Rezoning Transportation Analysis

Petition Number: 2022-140

Date	Description
1-26-23	First Review (PDM)
2-22-23	Second Review (JP)

RZ1.0

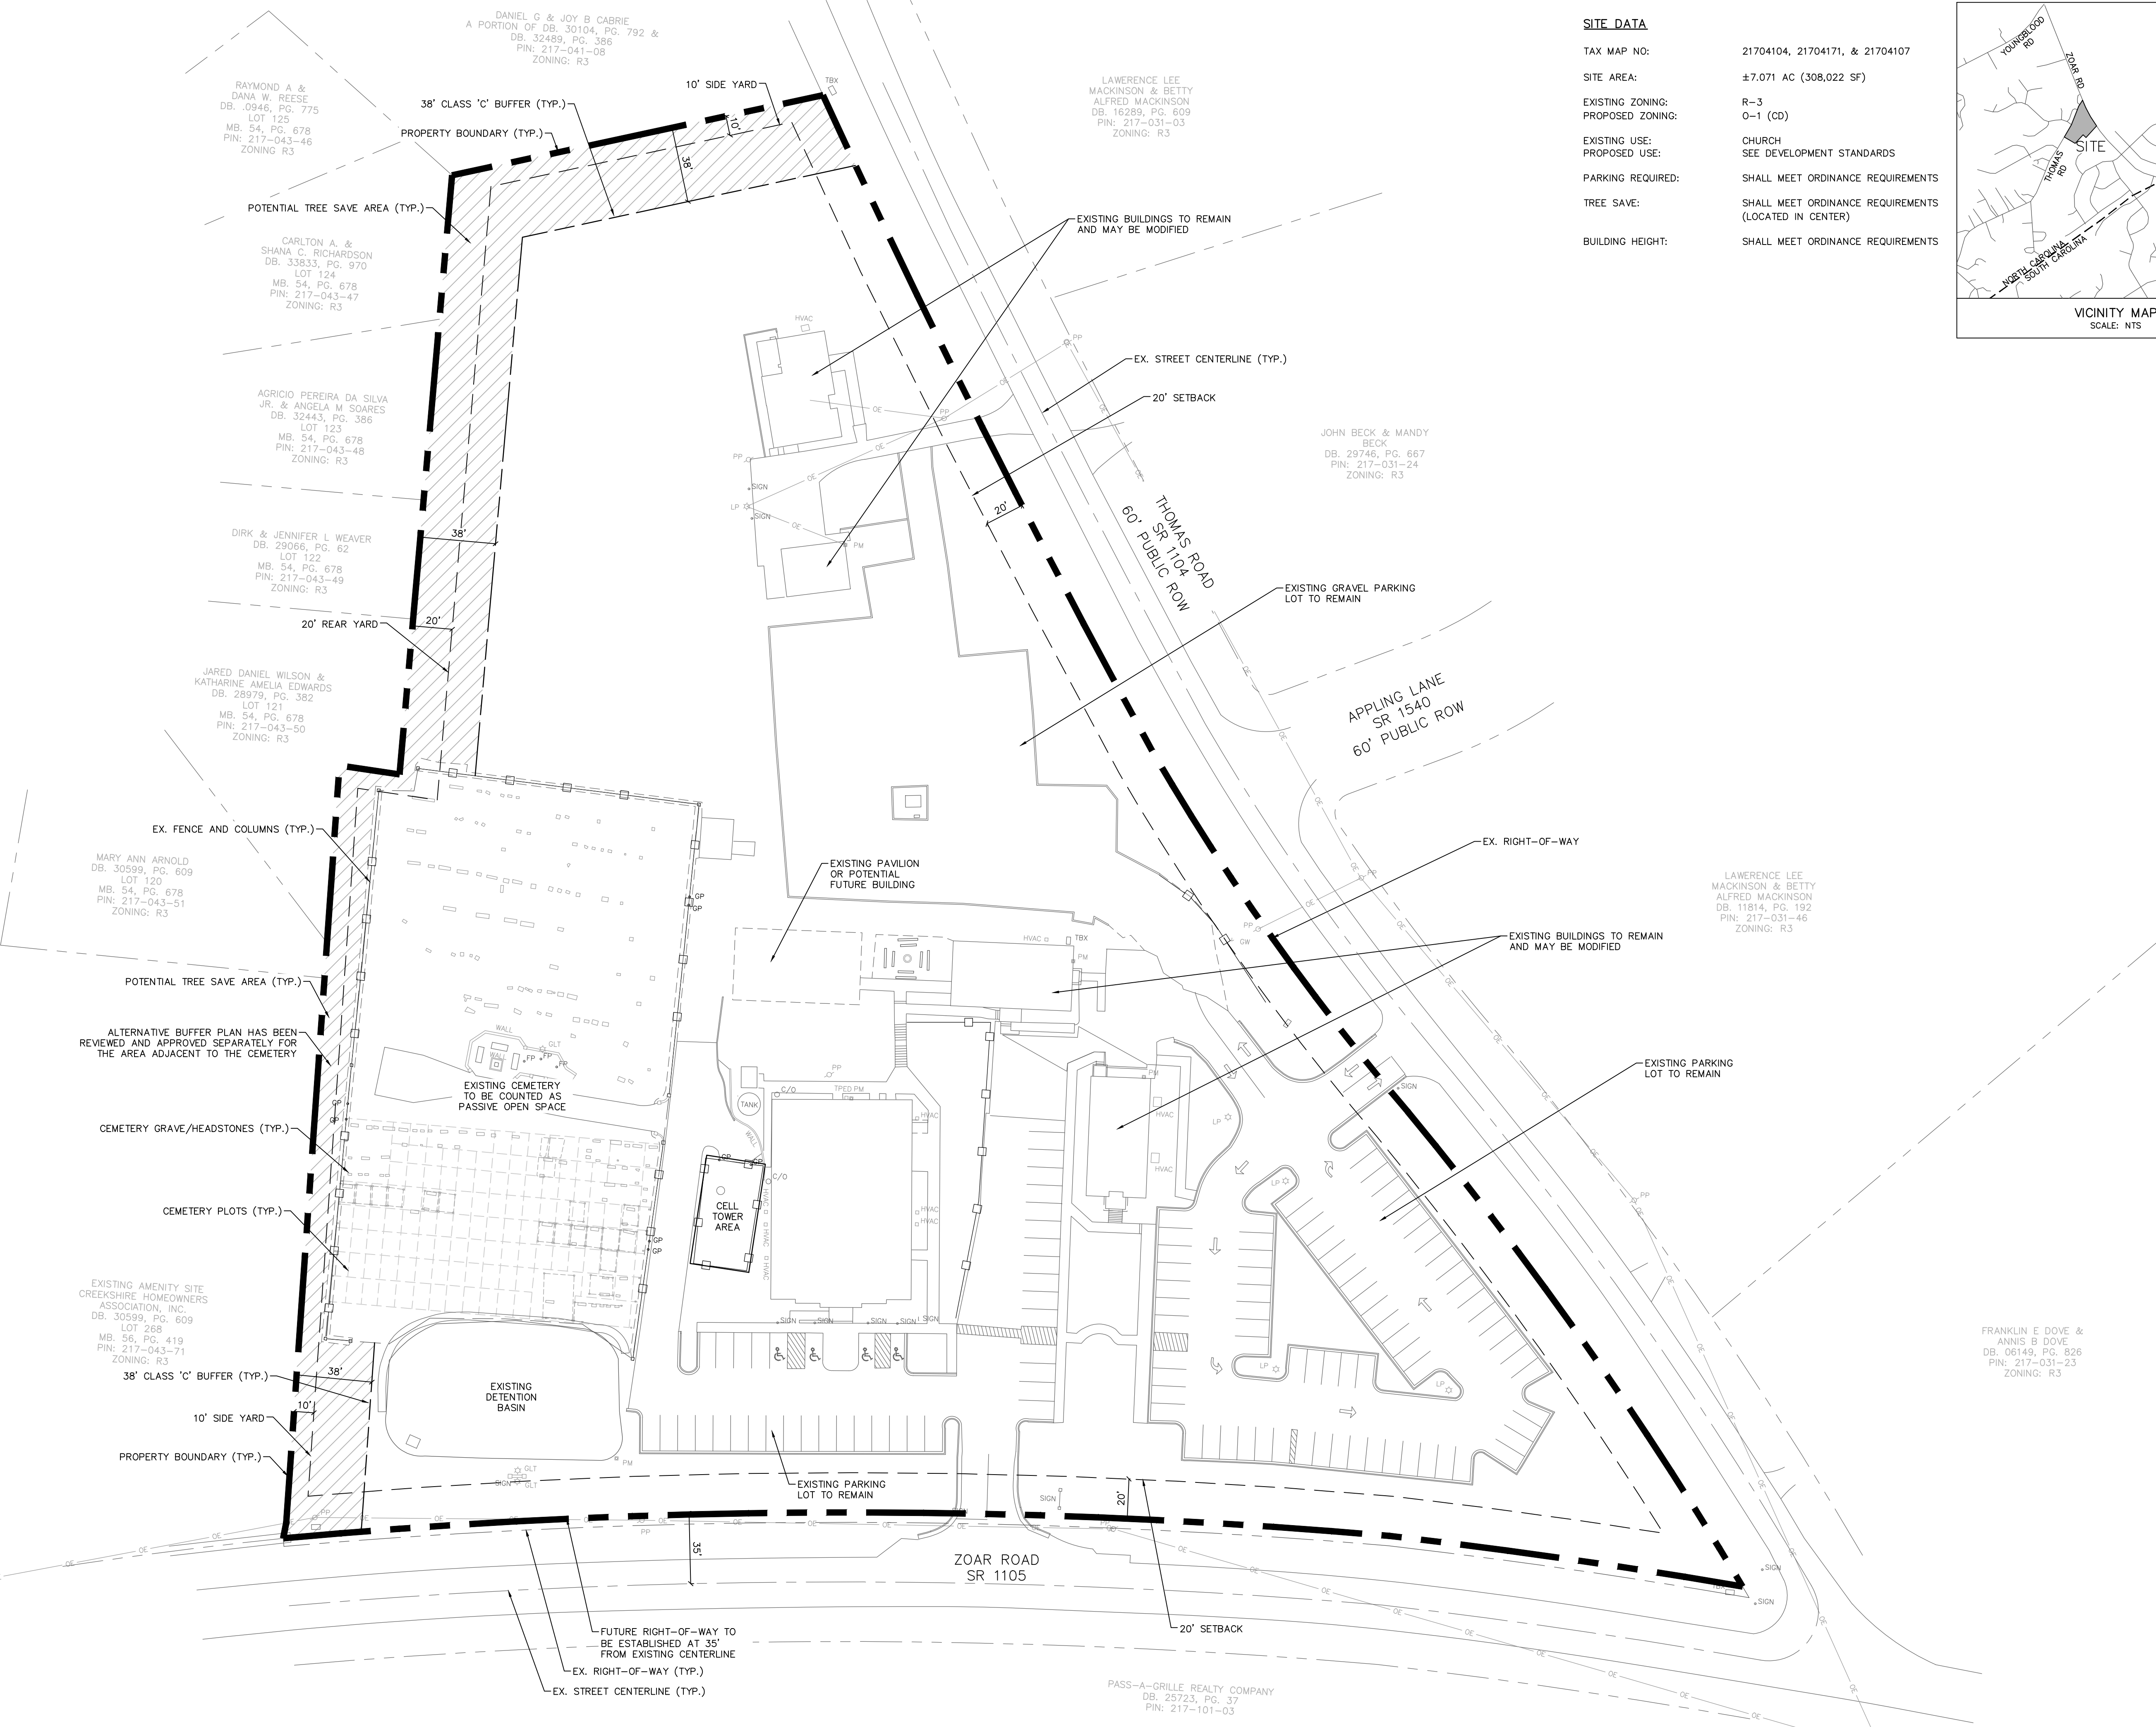
1. Curblines:

Zoar Road: Location of curb and gutter to be located 19 feet from roadway centerline to accommodate the Charlotte Streets Map with a roadway typical section of a two plus lane avenue with shared use path.

Thomas Road: Location of curb and gutter to be located 17.5 feet from roadway centerline to accommodate the Charlotte Streets Map with a roadway typical section of a two plus lane avenue with sidewalk. The location of curb and gutter is in accordance with CLDSM U-06 for local collector.

Label and dimension the curb and gutter from the centerline for each road on the site plan.

Clarifying Comment from 2-22-23: Dimension the future back of curb from the centerline on both Zoar Road and Thomas Road

3. Revise site plan and conditional note(s) to commit to dedicate 35 feet of right-of-way from the road centerline on Zoar Road. The site plan shall label and dimension the right-of-way from the road centerline. If greater than 35 feet of right-of-way exists dimension the existing right-of-way from the road centerline.

Clarifying Comment from 2-22-23: Add conditional note

4. Revise site plan and conditional note(s) to commit to construct an 8-foot planting strip, and 6-foot sidewalk on Thomas Road per Chapter 19. The site plan shall label and dimension both items from the back of curb and gutter or edge of pavement.
5. Revise site plan and conditional note(s) to commit to construct bicycle facilities by installing a 12' multi-use path on Zoar Road to meet the Council-adopted Charlotte BIKES Policy. Multi-use paths maintained by the City shall meet ADA/PROWAG requirements.

Clarifying Comment from 2-22-23: Extend sidewalk on Zoar Road across the site's frontage to extend the existing pedestrian network.

8. If site is to remain in the ETJ: Revise site plan and conditional note(s) to construct 8-foot planting strips and 12-foot sidewalks on Zoar Road and 8-foot planting strips and 6-foot sidewalks on Thomas Road. The site plan shall label and dimension both items from the back of curb and gutter or edge of pavement. Add conditional note: The entire facility must be outside of the right of way and within a public access easement. Add conditional note committing to construction and maintenance of the sidewalk facilities on Zoar Road and Thomas Road.
